Preliminary Acceptance Punchlist

El Paso County – Department of Public Works - Stormwater Section

Project Name:	Monument Academy CDR (road & roundabout)
EDARP Filing Number(s):	CDR201, CON2025 Also Reference: PPR199, CDR191, & MS2110
ESQCP Number:	ESQ1930 (Shared with school construction)
Attendees:	DPW SW: Shannon Mustoe, Joshua Augustenborg, Benjamin Jones DPW Development Services: N/A Developer: Matt Dunston
Date of Walk-through:	09-16-2024
Walk-through Number:	3 rd (First was 07/21/22, second was 01/25/2024)

EPC 5/27/2020 C3.1

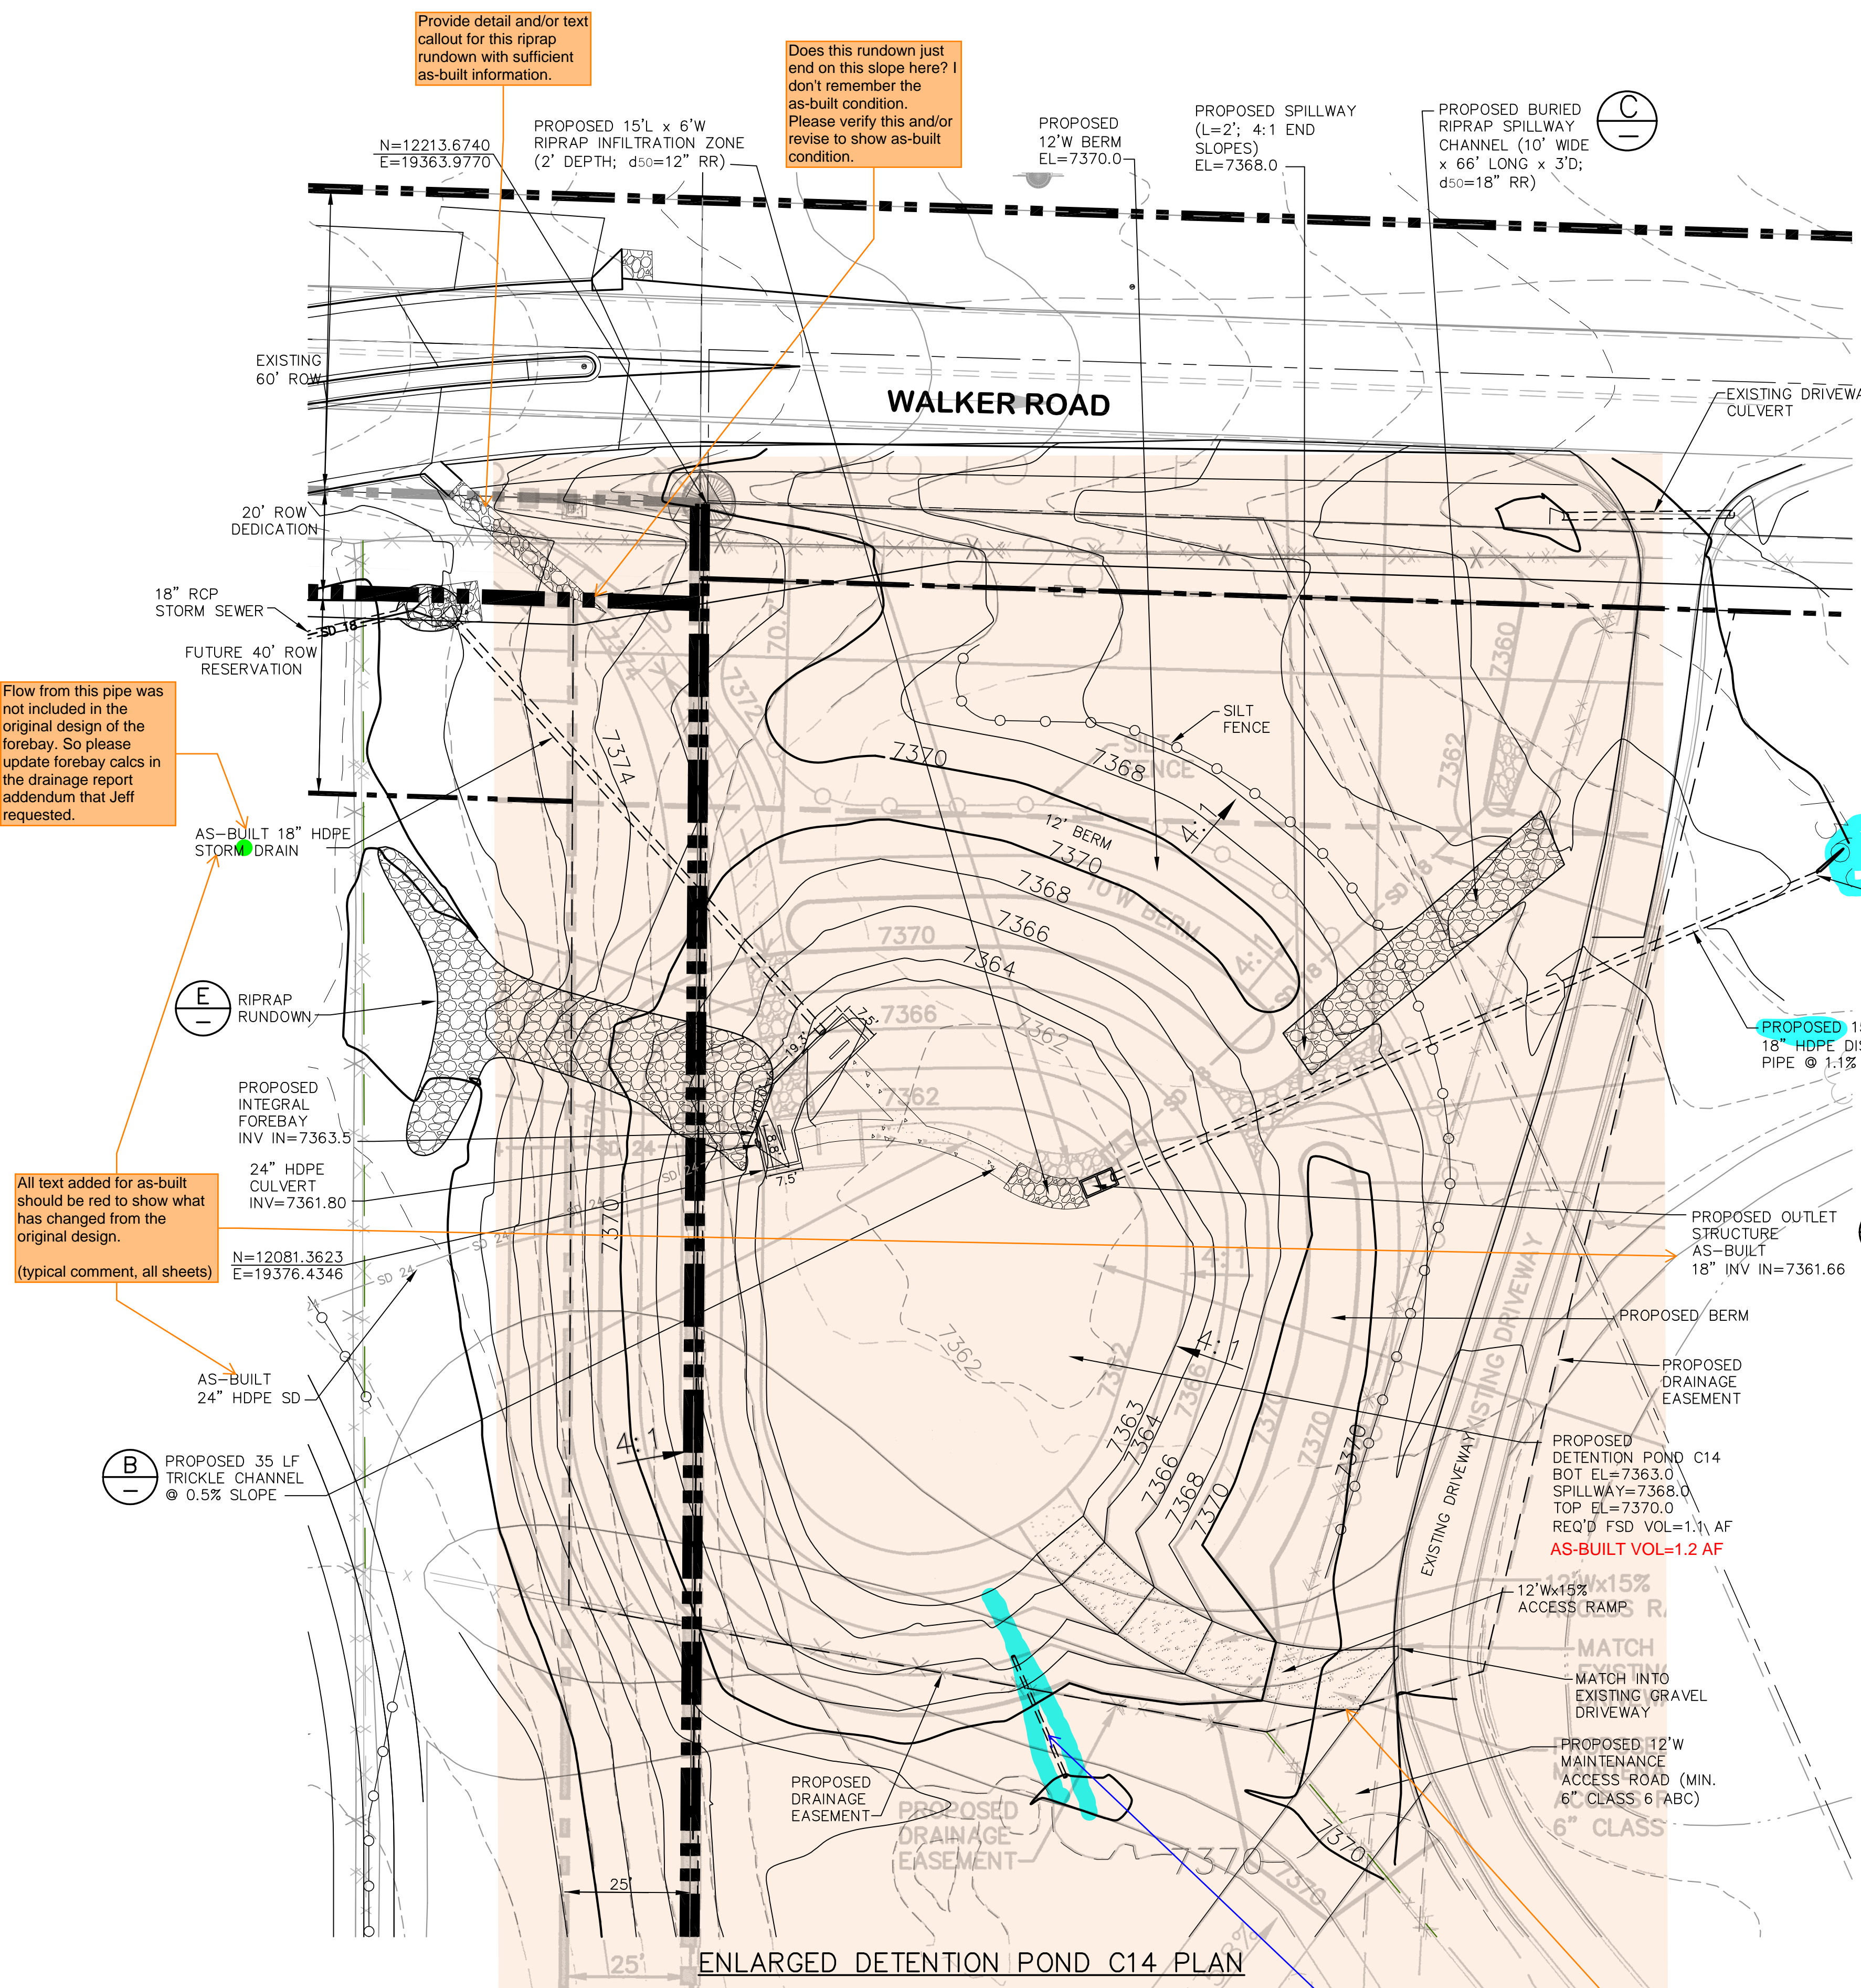
Pond M3 [Reference sheets C2.0, C2.2 and C3.1 of Grading and Erosion Control Plan]:

- Outlet Structure
 - Bottom orifice hole clogged on orifice plate
 - Clean out outlet structure and outlet pipe
 - Clean out outlet structure and outlet pipe

- Tubular trash rack not installed on angled front of outlet structure
 - Consider need for safety rail around outlet structure to prevent safety incidents

- Install orifice plate gasket.
 - Install Johnson Vee Wire trash track.
- Forebay
 - Clean out sediment that has accumulated in the forebay.
 - Regrade around forebay and re-install riprap to fix bypassing.

- Outfall
 - Extend riprap apron from outfall to Hwy 83 culvert per plan
 - Install flared-end section per plan
- Trickle Channel
 - Trickle Channel is not installed or is 100% buried and will need to be cleaned to verify installation/condition.

- 15'x6' riprap pad at bottom of trickle channel not visible due to sediment accumulation. Excavate sediment and reestablish riprap.
- The maintenance access road was rerouted to be from the north instead of from the southeast. However, the new northern access does not connect to the ramp that leads down the pond embankment to the forebay. Connect the new northern road to the existing southern ramp or cut in a new ramp down to the pond bottom since it is likely infeasible to cross channel M2.3A.

- Remove sediment from pond bottom and stabilize. Estimated sediment depth to be 12-18" deep based on forebay being completely buried.
 - Regrade to have positive drainage into forebay, trickle channel, and outlet structure.
- Remove sediment that has accumulated at the toe of the northeastern slope from erosion of that embankment and repair and stabilize slope erosion.
- 2ft curb chase at Jane Lundeen adjacent to the upstream end of Channel M2.3A See Sheet PP2.
 - Due to sediment accumulation, there is no positive drainage into the curb chase so it is being bypassed. And the runoff must make a >90deg turn to make it to the channel, so recommend installing the rundown at a more gradual angle
- Repair blowout on western slope of pond.
